**PROPOSED MIXED USE DEVELOPMENT
RESIDENTIAL, AFFORDABLE HOUSING, HOTEL & COMMERCIAL OFFICES
2-4 BURLEIGH ST & 20-24 RAILWAY PDE, BURWOOD**

SSD-77260958

Architectural Response to DPHI Request for Information

This document is prepared in response to DPHI's Request for Information emailed dated 22 December 2025 :

LEVELS 3-18 VISUAL PRIVACY TO SIDE BOUNDARY

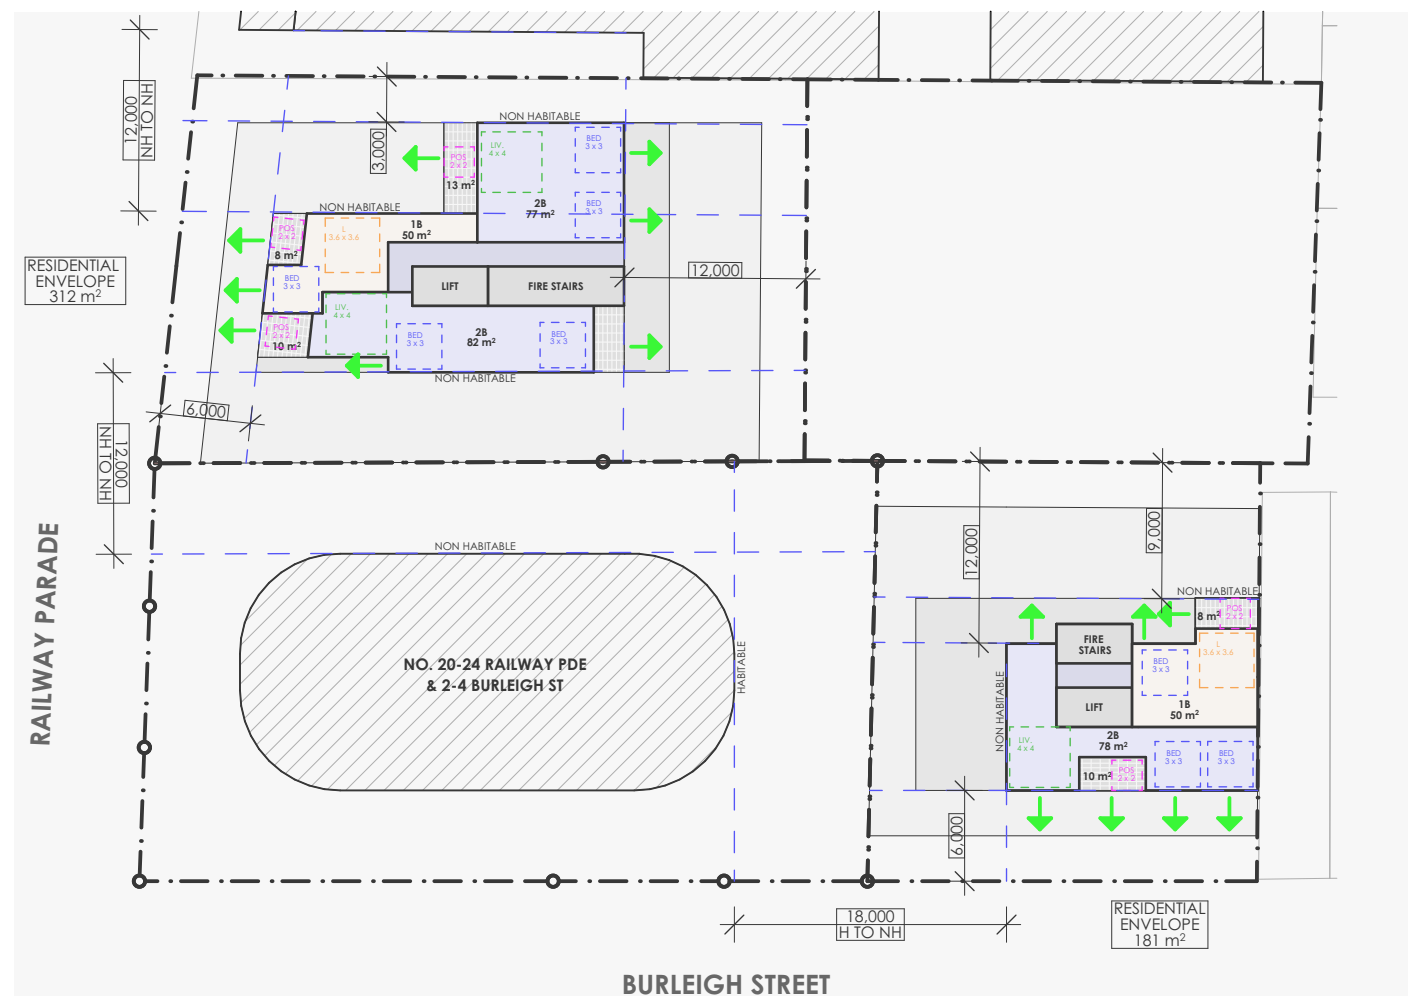
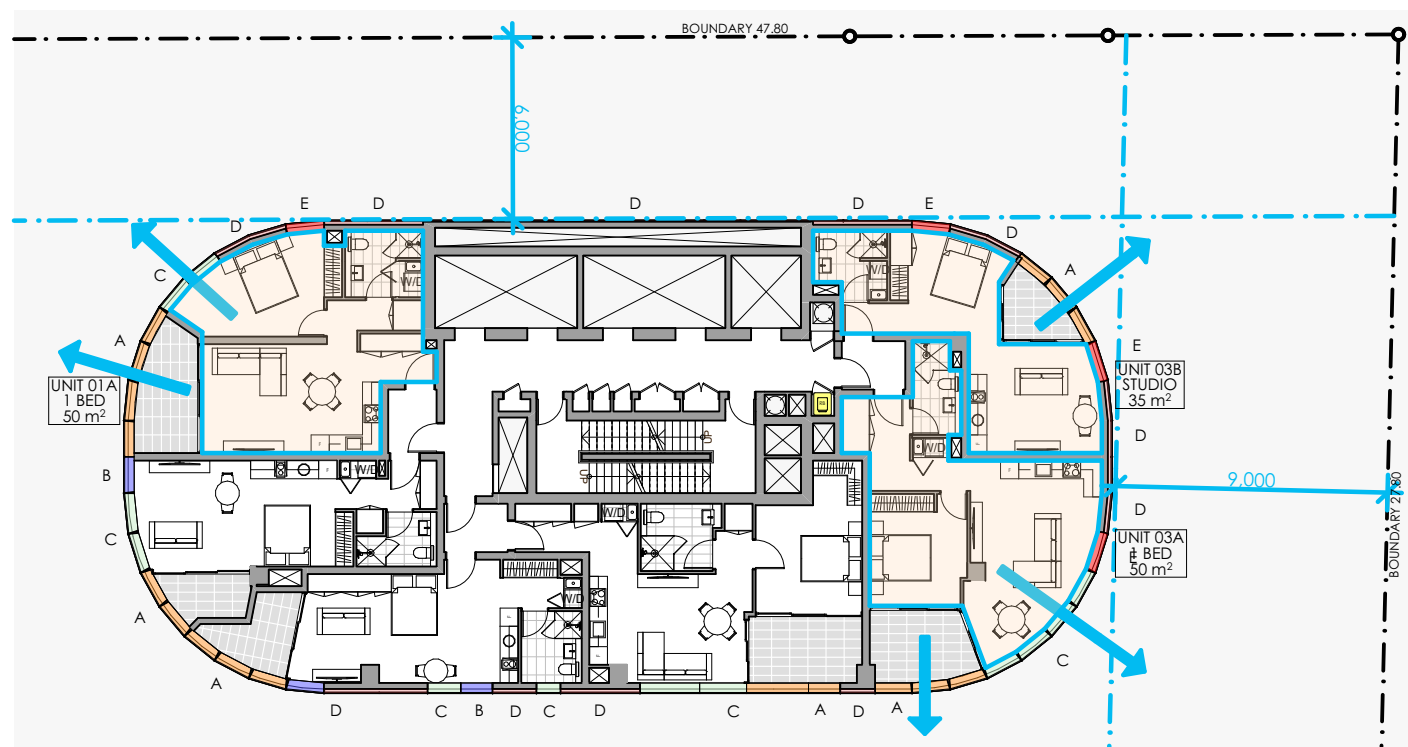
Provide examples of opaque glazing types which allow for both privacy and solar access to living spaces.

Potential glazing solutions that allow for both privacy and solar access to living spaces are:

Frosted glass -

The glass surface is sandblasted or acid-treated to blur the view while still allowing significant light to pass through,

Window film -

Adhesive films can be applied directly to windows to mimic the effect of frosted, patterned, or tinted glass.

LEVELS 3-18 ACOUSTIC NATURAL VENTILATION PLENUMS

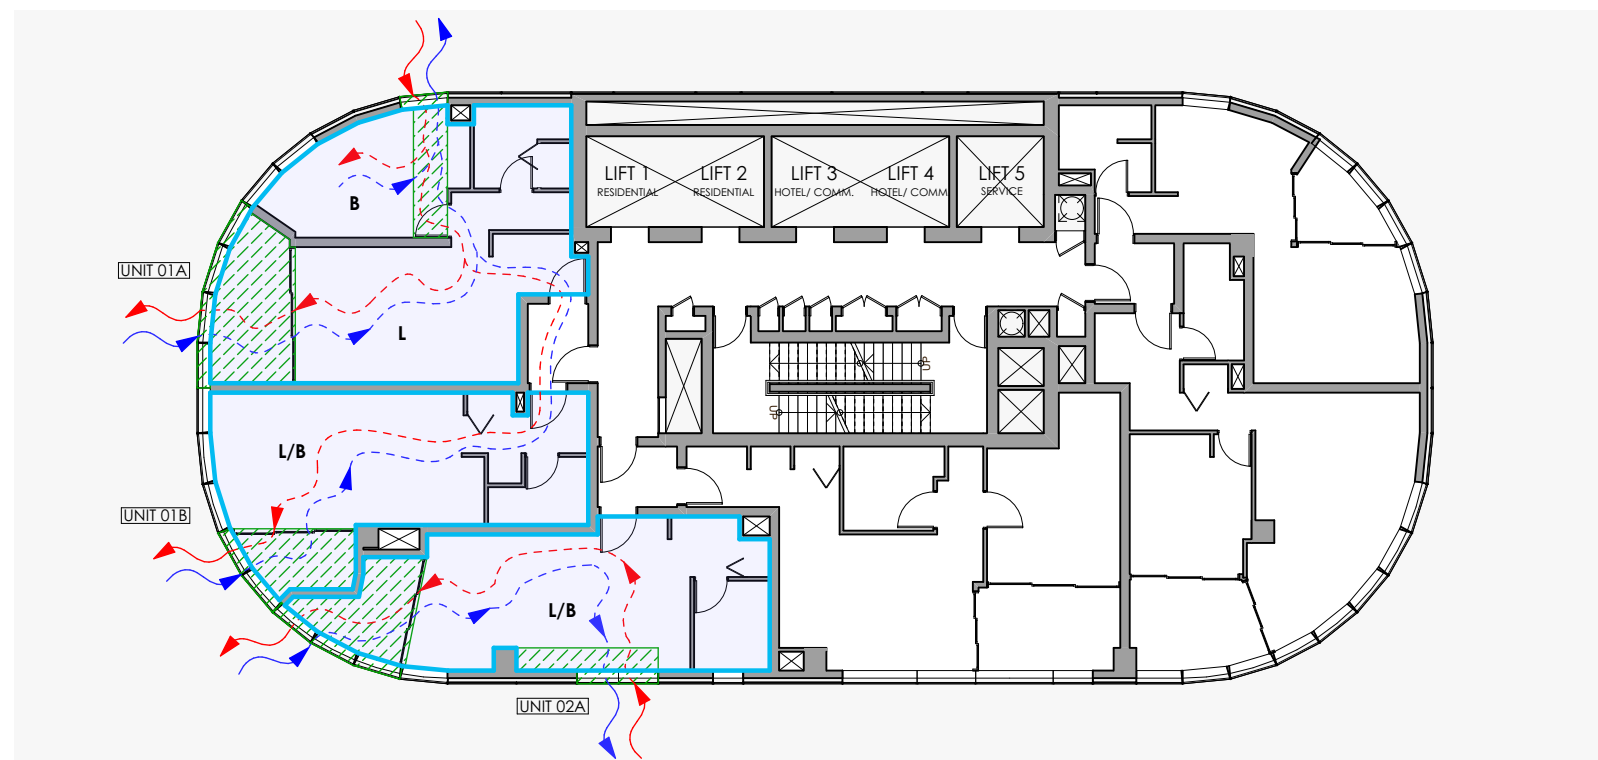
Clarify whether plenums will be the only mechanical ventilation proposed and provide advice from the wind consultant that sufficient air flow will be available to apartments for ventilation via the proposed plenums.

The Acoustic Advice notes that Units 2B, 3A and 3B will be provided with mechanical ventilation. Confirm whether this will be same type of mechanical ventilation as Units 1A, 1B and 2A and similar to Item 5 ensure that the advice from the Wind consultant confirms that adequate airflow can be achieved.

These plenum systems are designed in conjunction with Acoustic and Wind Consultants to provide passive natural ventilation and will be designed in detail at CC stage to suit the specific situation to meet all requirements for compliance. An example of such system is shown below.

Such systems are specifically designed to provide a passive based solution that allows for natural ventilation whilst mitigating external noise intrusion, without the reliance on mechanical based solutions.

The plenum systems proposed are to provide natural ventilation whilst eliminating external noise intrusion.

They are proposed to any units that are required to be naturally cross ventilated yet are affected by external noise intrusion.

Units 1A, 1B & 2A are proposed to implement the plenums as these units have been identified as being impacted by excessive external noise intrusion due to its orientation to the external noise sources.

Units 2B, 3A & 3B are not impacted by the external noise sources, therefore are not proposed to require the implementation of plenums.

LEVELS 19 & 32 PLANT/ SERVICES

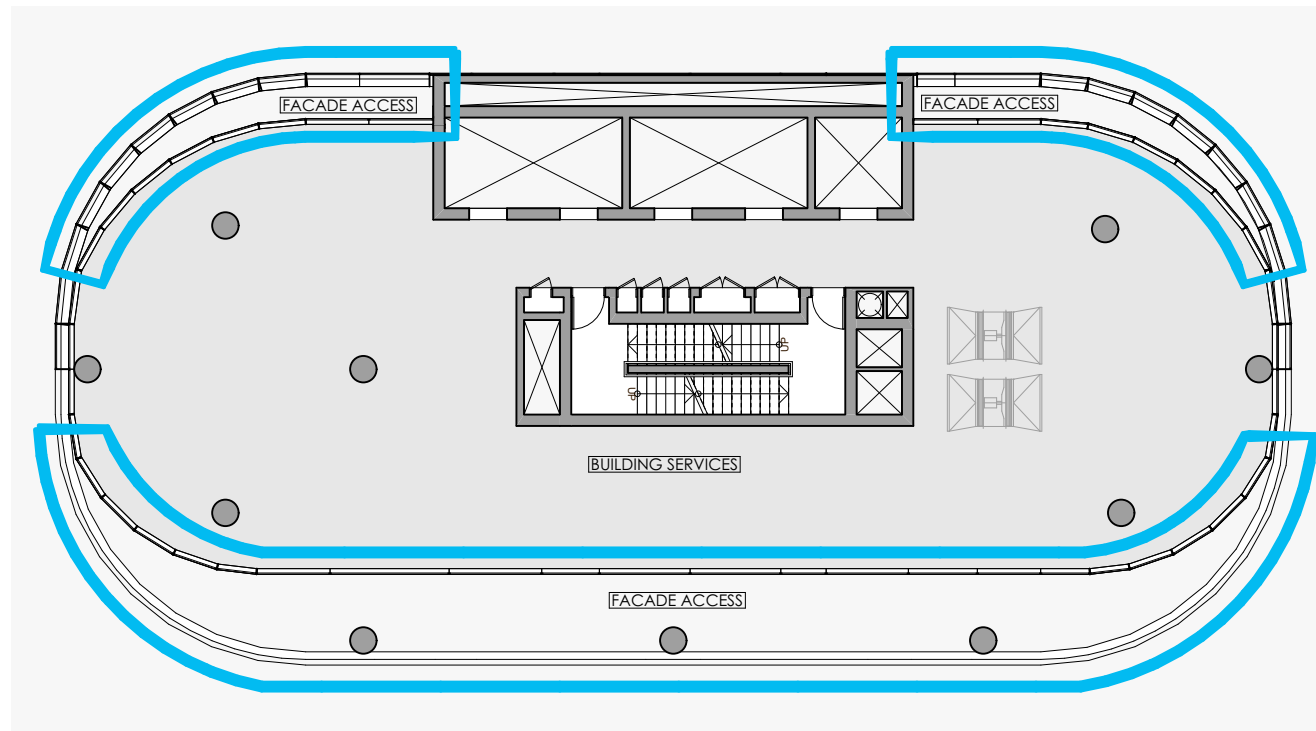
Building Design Item 12 Item 12a - The Amended Services Coordination Set advises to review Level 16 for the services plan for Level 19. However, Level 16 is a residential floor and Level 19 is plant room floor. Provide details of the plant needed for Level 19 similar to the plan details provided for Level 32. Item 12b – a response this matter has not been provided.	The reference to "Level 16" on the Amended Services Coordination Set is a typing error carried through from previous iterations of the building design where the split of where residential levels, hotel room levels and plant room levels were allocated differently. The plant floors are located on Level 19 and Level 32. The entire Level 19 is allocated for the AC mechanical equipment servicing the residential Levels 13 -18, and the hotel room Levels 20 - 31. Further to this, the intent is that AC condenser units will not be located on any residential balconies. The Services drawings are now amended to show correct Level references and plant equipment on Level 19.
